**KIRKLEES METROPOLITAN COUNCIL
INVESTMENT & REGENERATION SERVICE**

Reference No: 2020/62/91000/E

Site Address: 38, New North Road, Heckmondwike, WF16 9DH

Description: Erection of front extension and dormer windows to both sides, increase in roof height and alterations

PROPOSED REAR ELEVATION

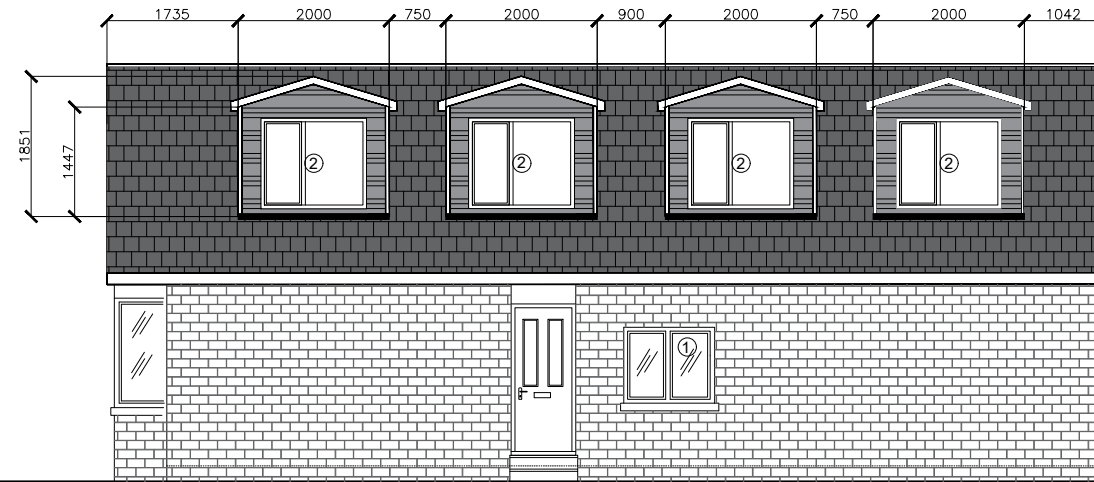
The proposals would alter the roof to become one encompassing twin pitched roof with gables to front and rear, the roof pitch would also be increased, resulting in a higher ridge. This in itself would result in a development which would be out of character with the surrounding development, however the proposals also include 6 dormer windows in the side facing roof slopes introducing additional incongruous elements into the streetscene.

With regard to other alterations the proposals would also result in the loss of the single chimney which again would affect the character of the development.

The proposed development, due to a combination of the increase in the ridge height and massing, the steepened roof pitch and the two dormer windows is likely to result in an increase in overshadowing of the solar panels, particularly during the winter months which may result in a decrease in the production of renewable energy. This would weigh against the proposals.

1. The proposed extensions and alterations, by virtue of a combination of the design and scale, would result in an inharmonious development which would be out of character with the surrounding development and appear as an incongruous development within the street scene. The proposal would therefore be harmful to the visual amenity of the area contrary to Policy LP 24 of the Kirklees Local Plan and Chapter 12 of the National Planning Policy Framework.

PROPOSED ROOF PLAN

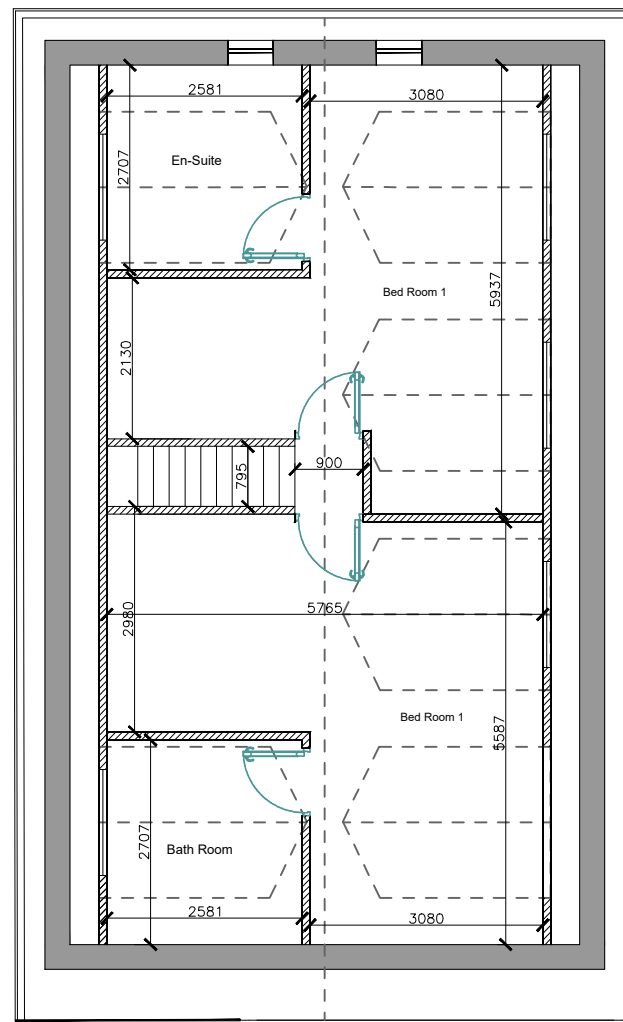
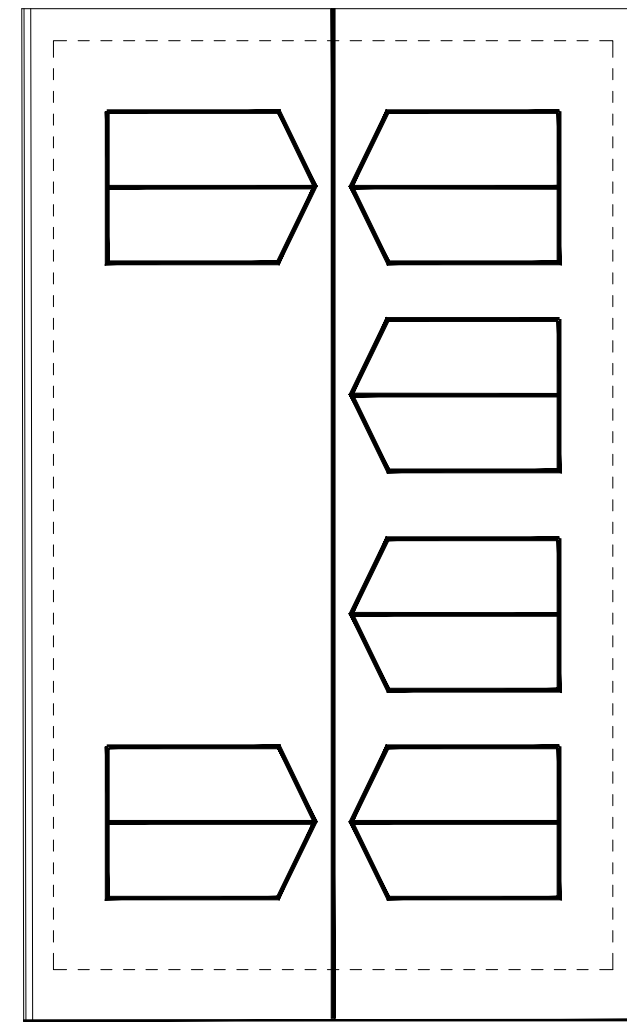
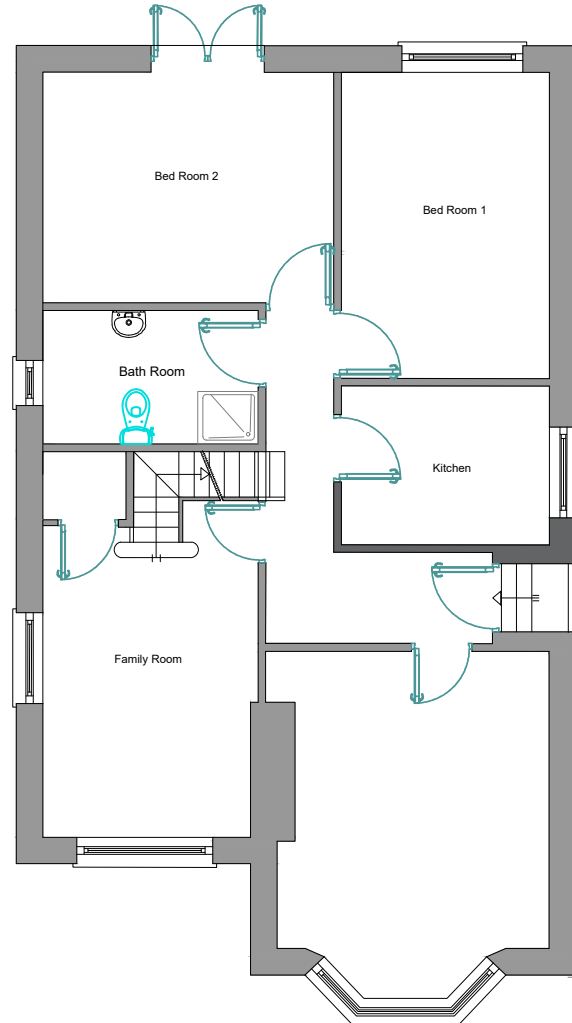
The proposed dormers would be to the side facing roof slopes and therefore have the potential to overlook neighbouring dwellings and gardens. With regard to the two dormers proposed on the north facing roof slope, these would serve bathrooms and as such would be obscurely glazed. This could be conditioned.

The 4 dormers proposed on the south facing roof slope would serve bedrooms, however the nearest dwelling on this side, no. 34 New North Road, is separated by the driveway of no. 38 and an access road serving no. 36 and other residential properties to the rear. As such there is approximately 10m to this property, therefore the impact on the residential amenity of the occupiers of this adjacent dwelling would be limited and is considered to be acceptable.
